Application No: LU/164/21/PL  
Site Address: Felix Dancewear 39 Beach Road Littlehampton BN17 5JA  
Description of works: Part change of Use from office/storage on first floor to 1-1 bed flat (resubmission following LU/100/21/PL). This site may affect the setting of a listed building & is in CIL Zone 4 (Zero Rated) as flats.

OWPC37832

PROPOSED FIRST FLOOR

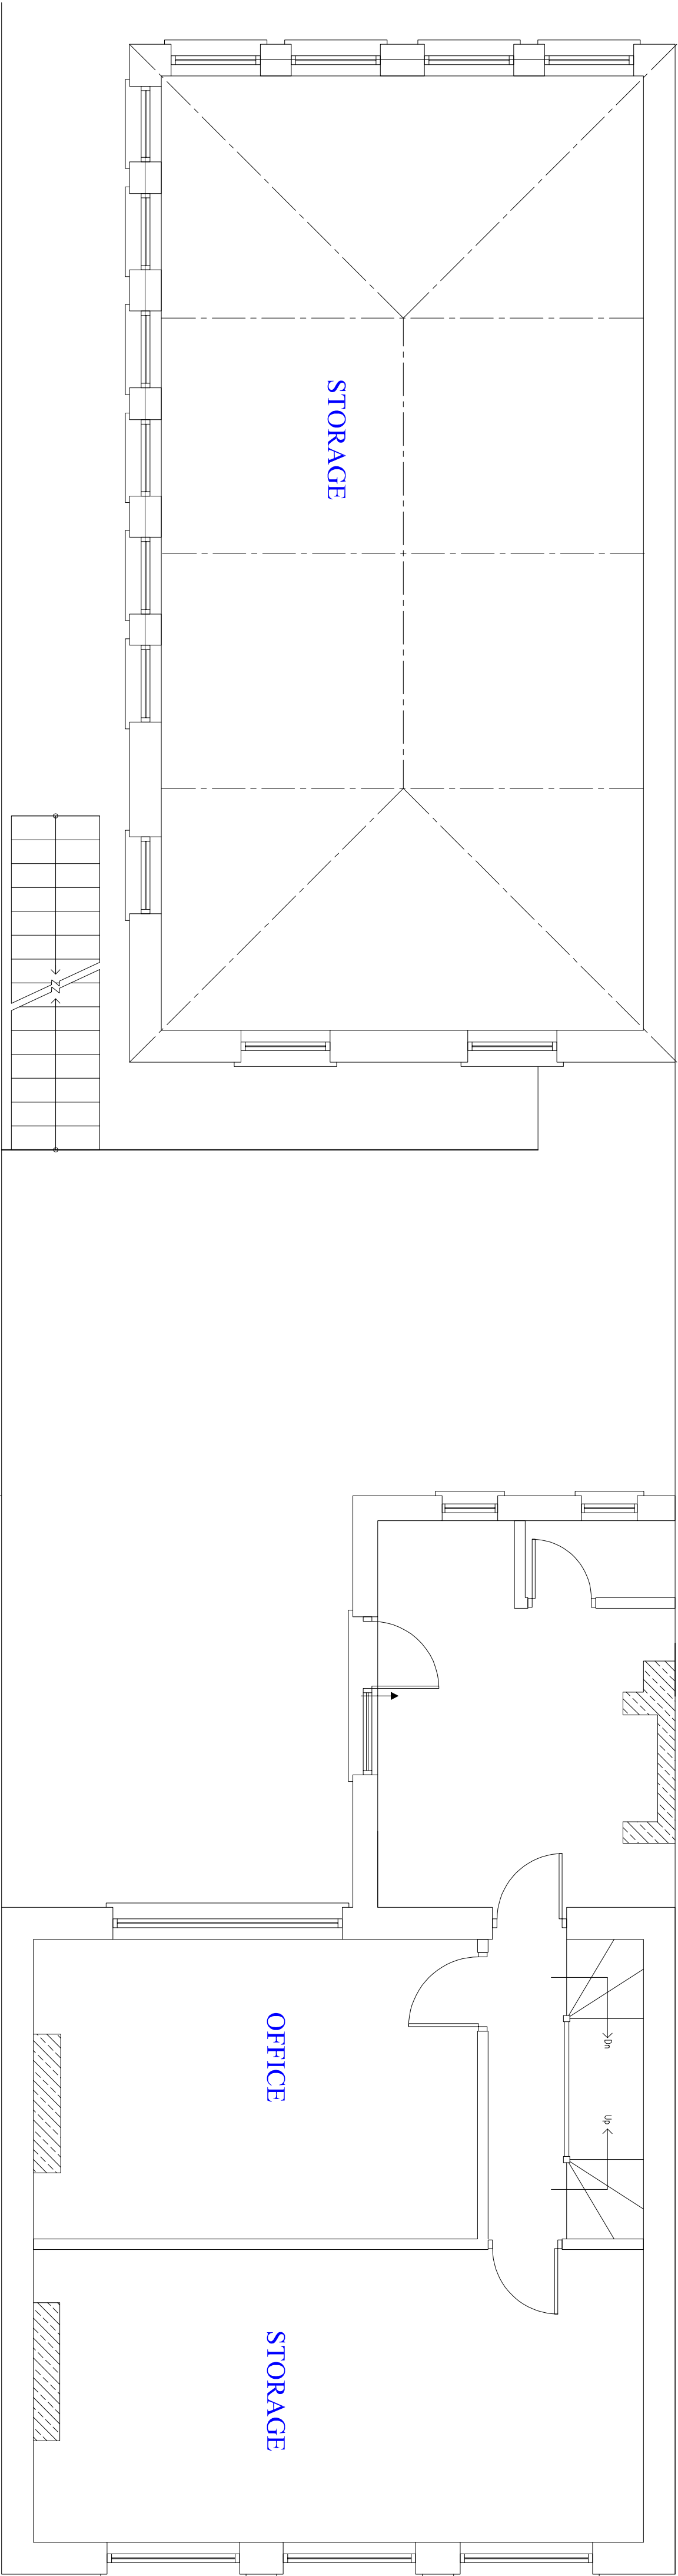
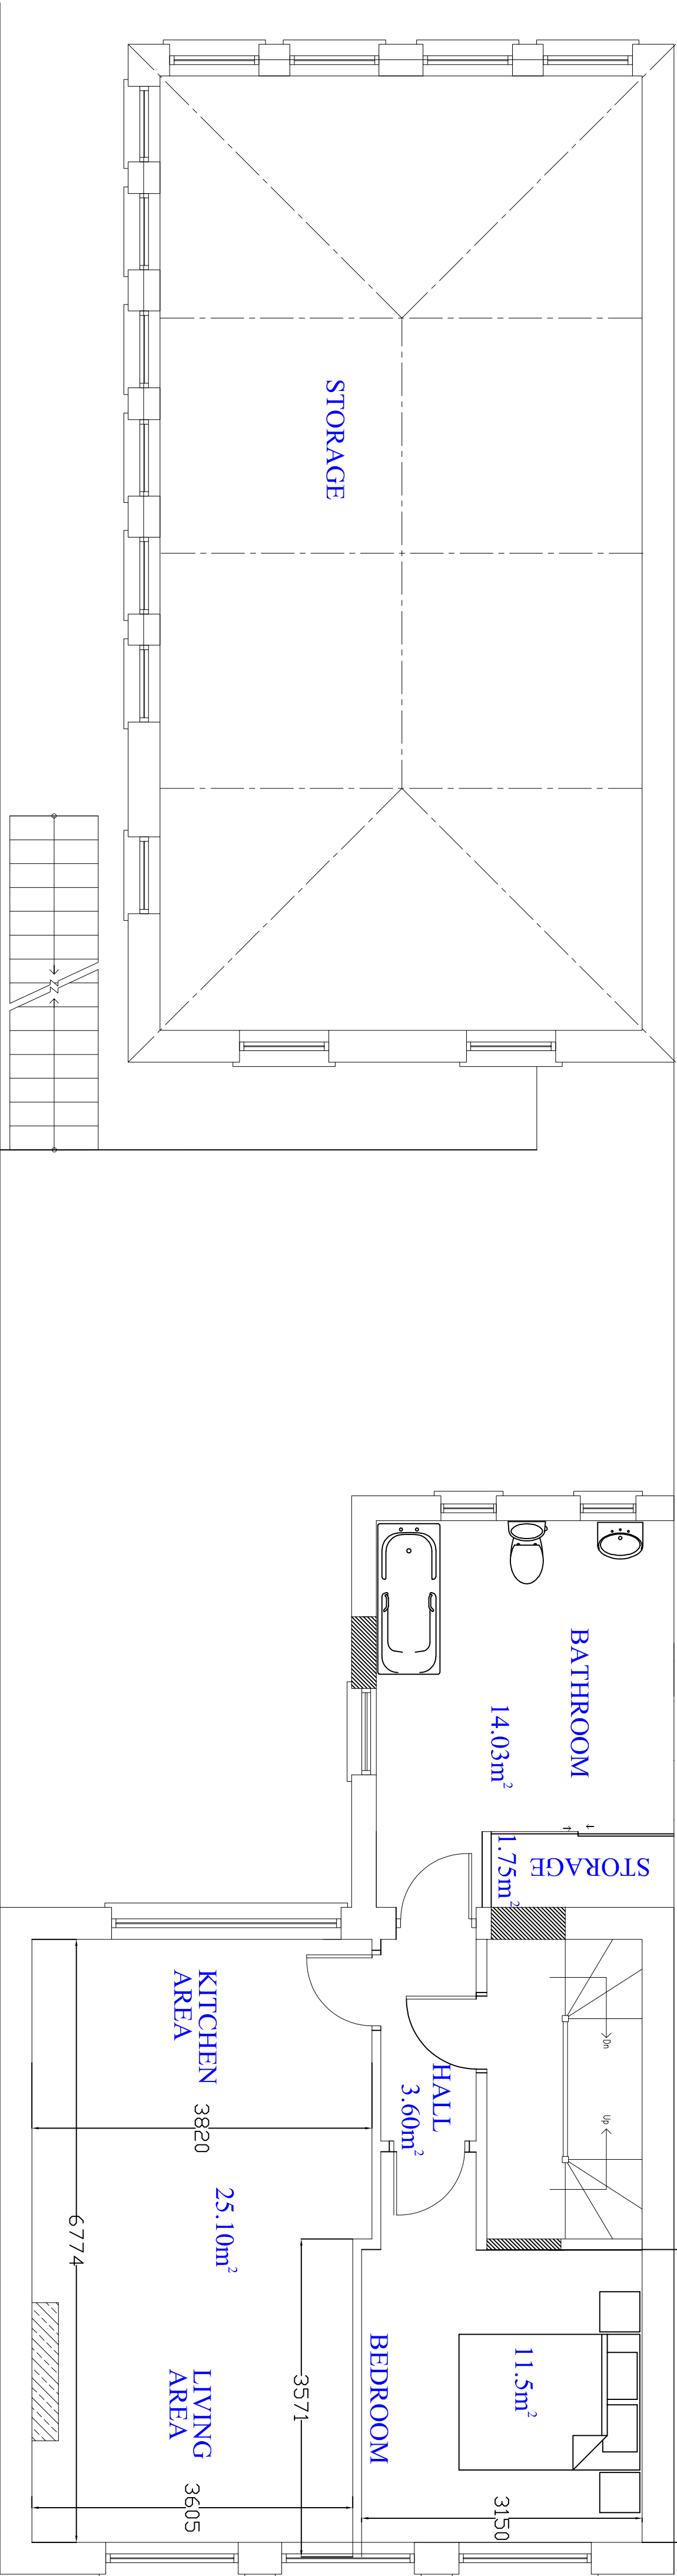
Further to our submission dated 22nd June 2021, the Town Council has since been advised that the changes in the internal layout show that the proposed bedroom now meets internal space standards. Noting this we therefore withdraw our objection.
